Sent: 22 August 2026 10:47
To: DC Admin
Subject: Planning application 2025/93355

Re:Planning Application 2025/93355 – Land off Woodward Court, Mirfield

I wish to raise a further formal objection following the latest highway proposals submitted by Bellway Homes.

Image 3.3 Proposed Woodward Court/Wellhouse Lane Improvements

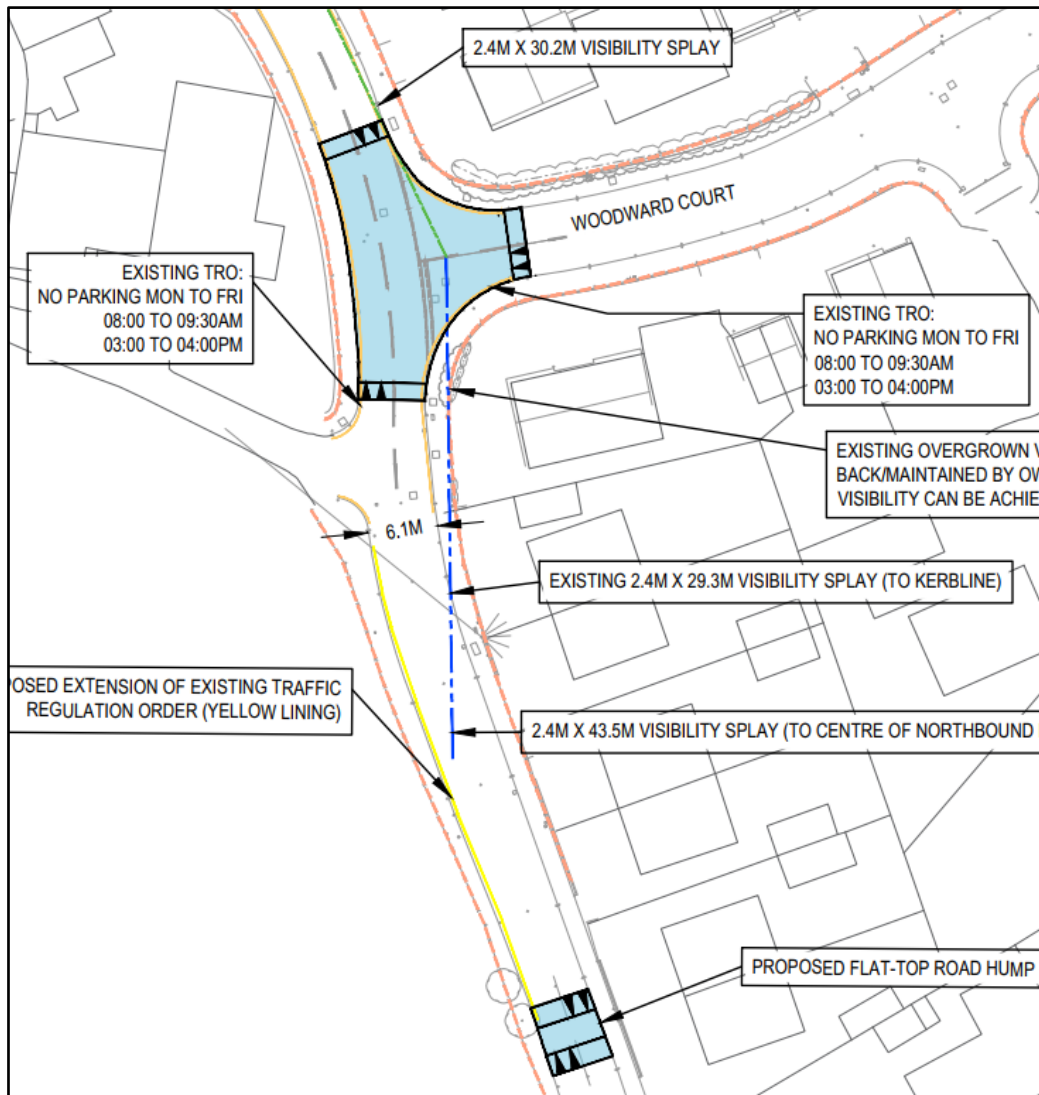
The proposed measures appear to address the consequences of additional traffic rather than the underlying problem: the existing road network is already unsuitable for significant traffic intensification. Introducing yellow lines, speed humps and a raised table may alter where vehicles park or how quickly they travel, but these measures do not increase the capacity of Woodward Court, Wellhouse Lane or Hepworth Lane. They therefore do not resolve the fundamental concerns about congestion and road safety.

The proposed double yellow lines on Wellhouse Lane and restrictions on Woodward Court will also remove existing parking opportunities. This could simply displace parked vehicles and congestion onto neighbouring streets rather than solving the problem. The measures appear primarily designed to make the development technically achievable rather than to improve the overall highway situation for existing residents.

Image 3.4 Proposed Hepworth Lane Site Egress

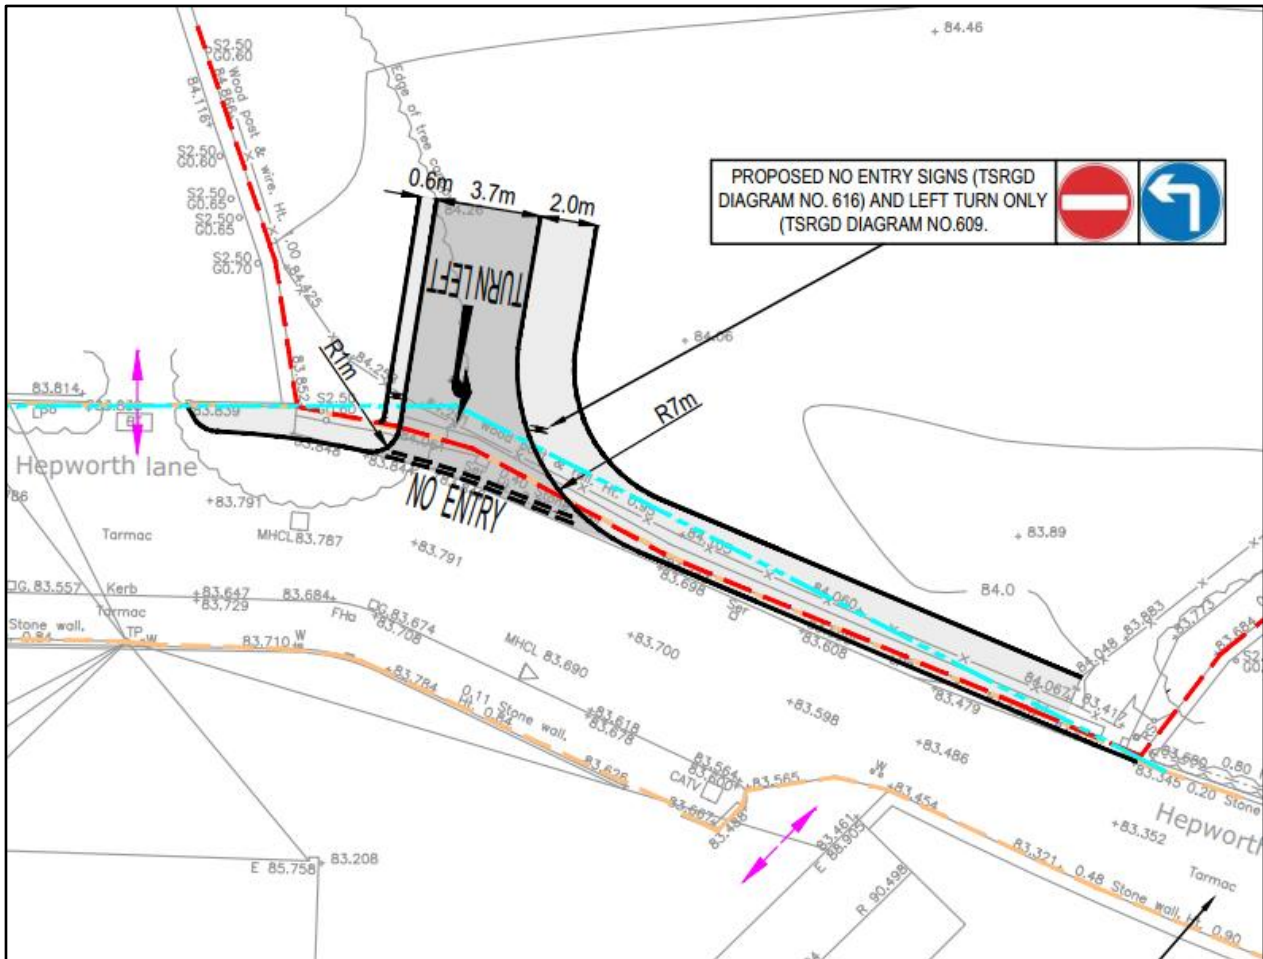
In particular, the proposed exit-only access onto Hepworth Lane is concerning. Hepworth Lane is a narrow, constrained road which is already difficult to negotiate safely. Increasing vehicle movements onto this lane, even if vehicles can only exit the development, would intensify existing problems. The applicant's own earlier consultation material acknowledges that highway congestion and safety were significant concerns raised by residents.
